# CITY OF ALBUQUERQUE

September 4, 2018

RE: **Juan Tabo Hills Estates**  
**Revised Grading Plan**  
**Engineer's Stamp Date: 8/30/18**  
**Hydrology File- M21D018; DRB# 1005278**

MARK GOODWIN & ASSOCIATES, P.A. CONSULTING ENGINEERS P.O. BOX 90606 ALBUQUERQUE, NEW MEXICO 87199 OFFICE (505) 828-2200, FAX (505) 797-9539	
CITY PROJECT NO.	ZONE MAP NO.	SHEET OF	
	M-21-Z	5	10

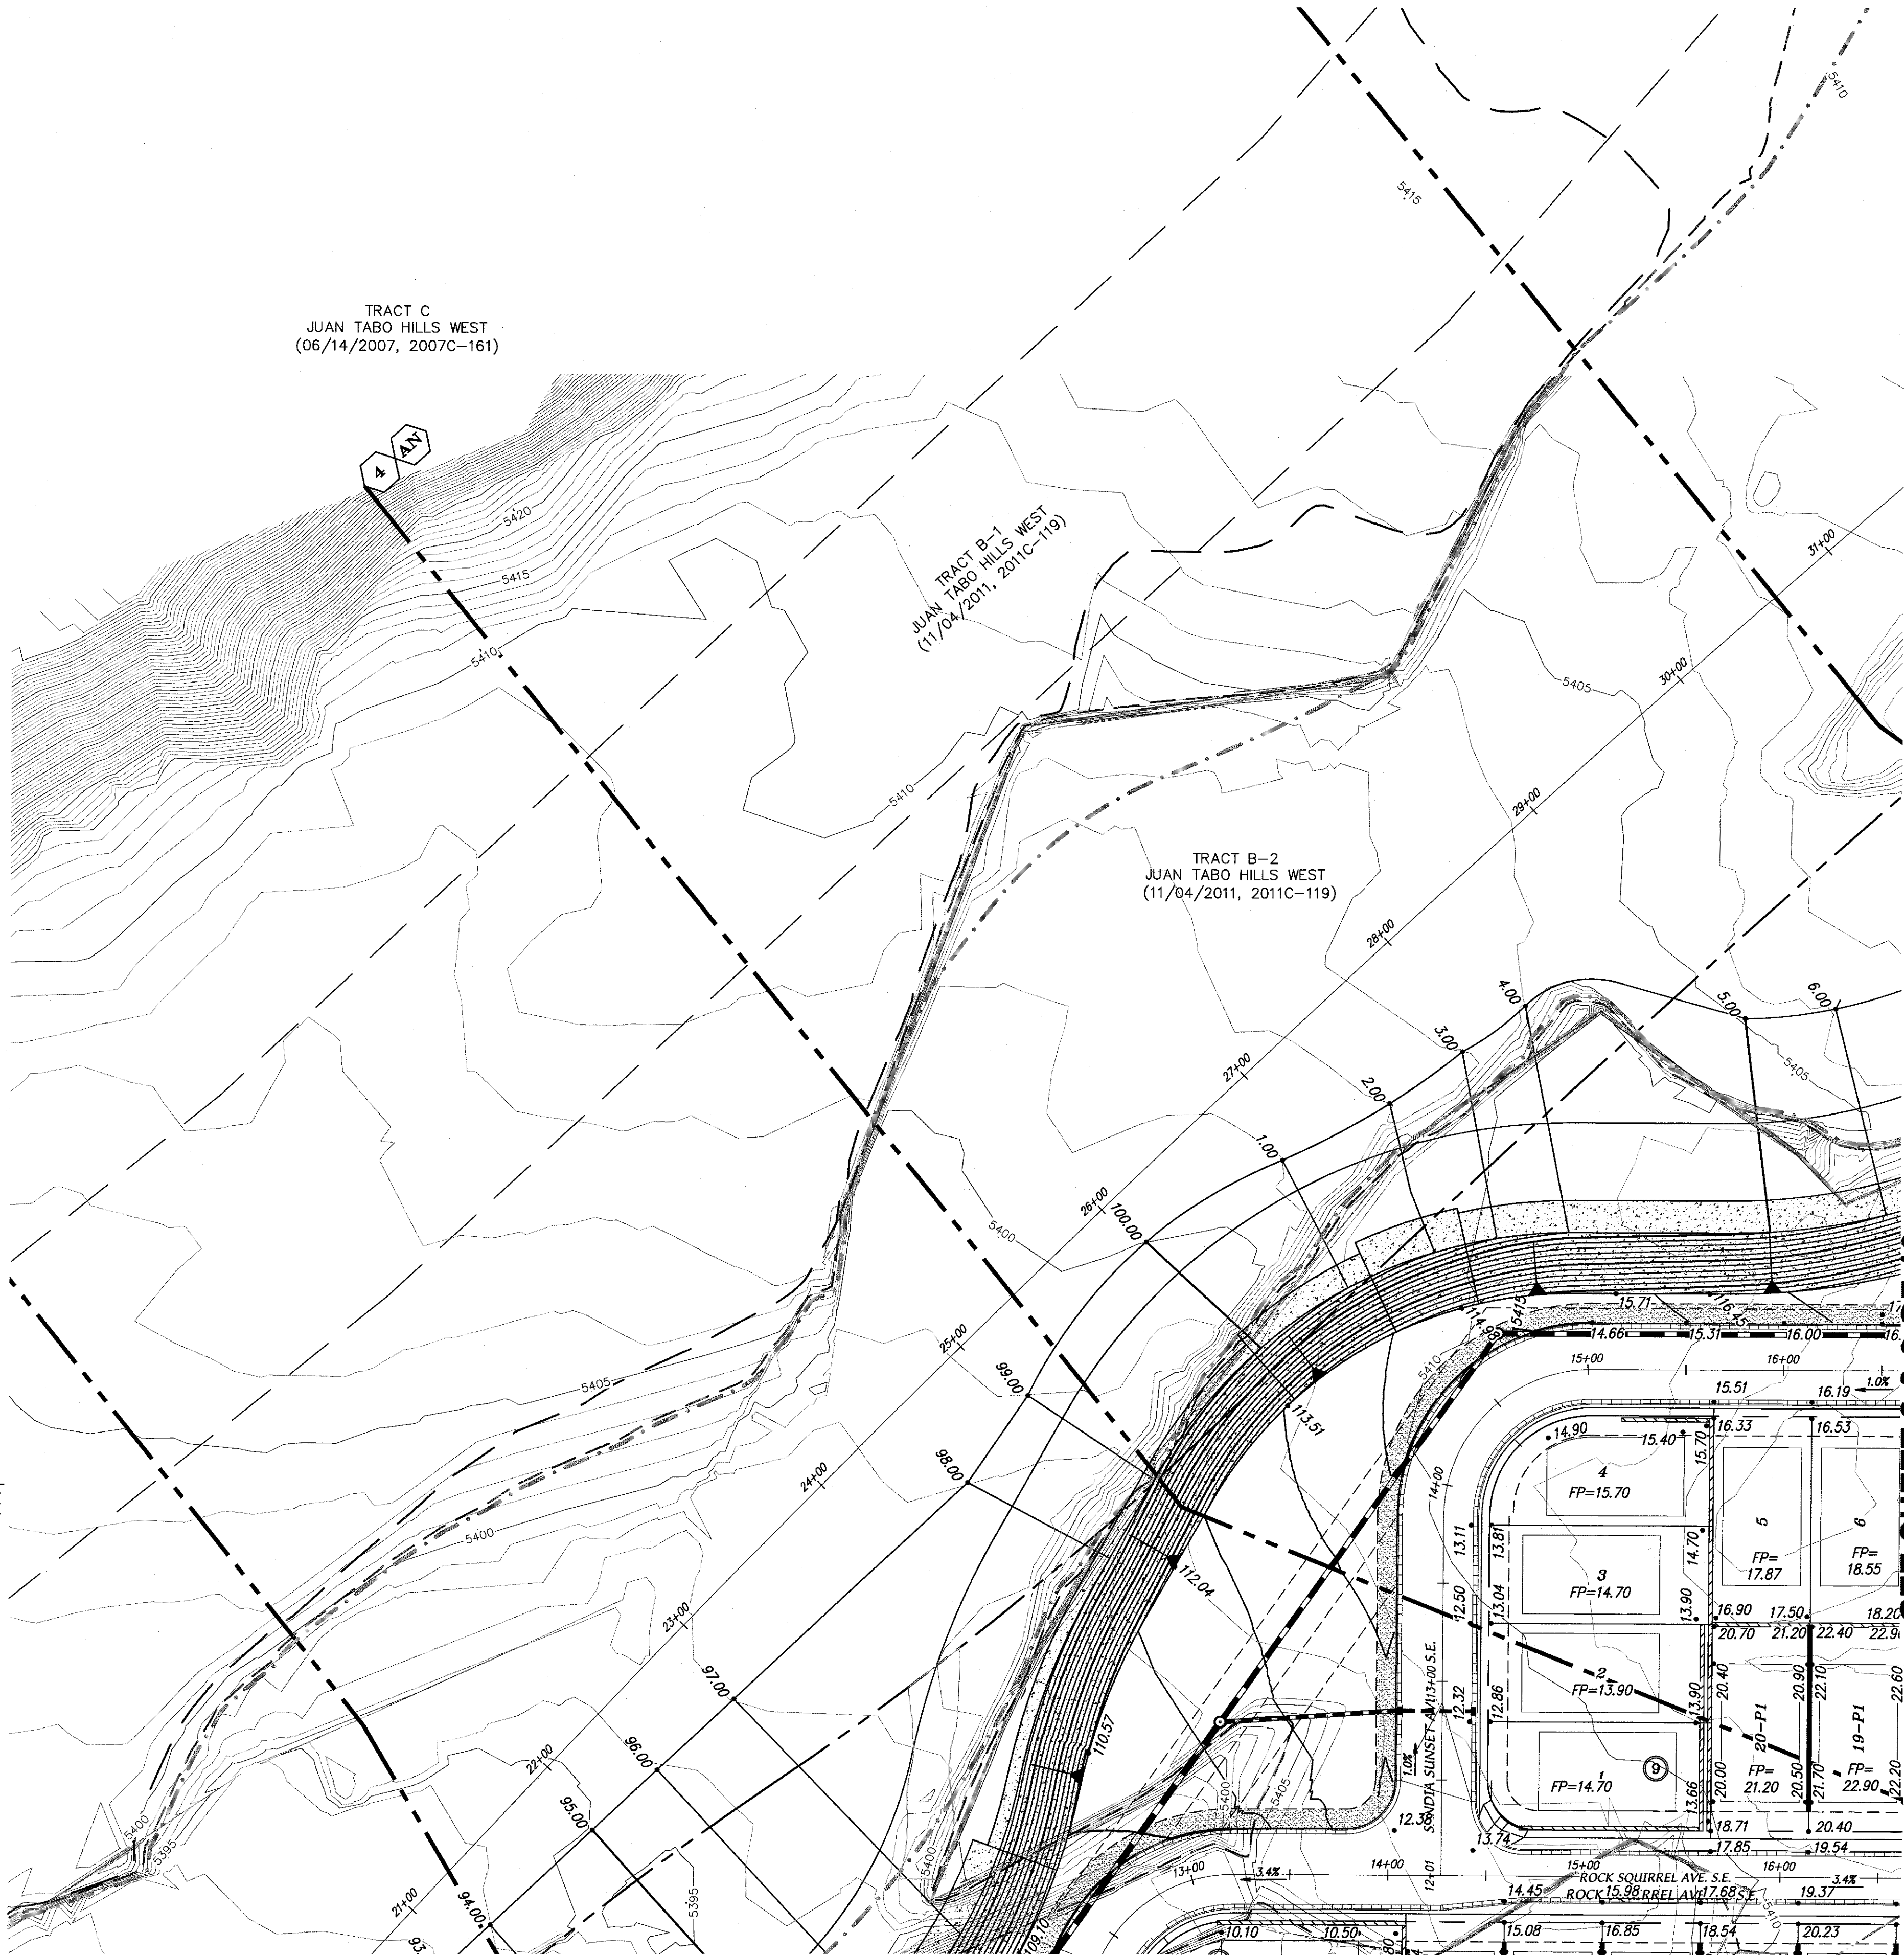
1. Provide self-ponding areas in the interspace (park) between the AMAFCA access road and the public road, or drain away from bank protection per AMAFCA direction. The contours and spot elevations should reflect the access road as sloping at 2% away from the top of shotcrete and back into the park area. If used, the ponding areas should be sized for the 10-day, 100-yr volume with supporting calculations provided. If this grading will be part of the landscaping plan, then the landscaping plan need to be included when resubmitting.
2. Provide rip-rap armoring at the outside bend of Sandia Sunset. If water surcharges out of the NMDOT inlet upstream near MH-47, flows will travel overland down Sandia Sunset and will likely jump the curb at this bend. Mark hand drew a detail and location of this on the previous submittal (sheet 5), but it did not get carried over this time:
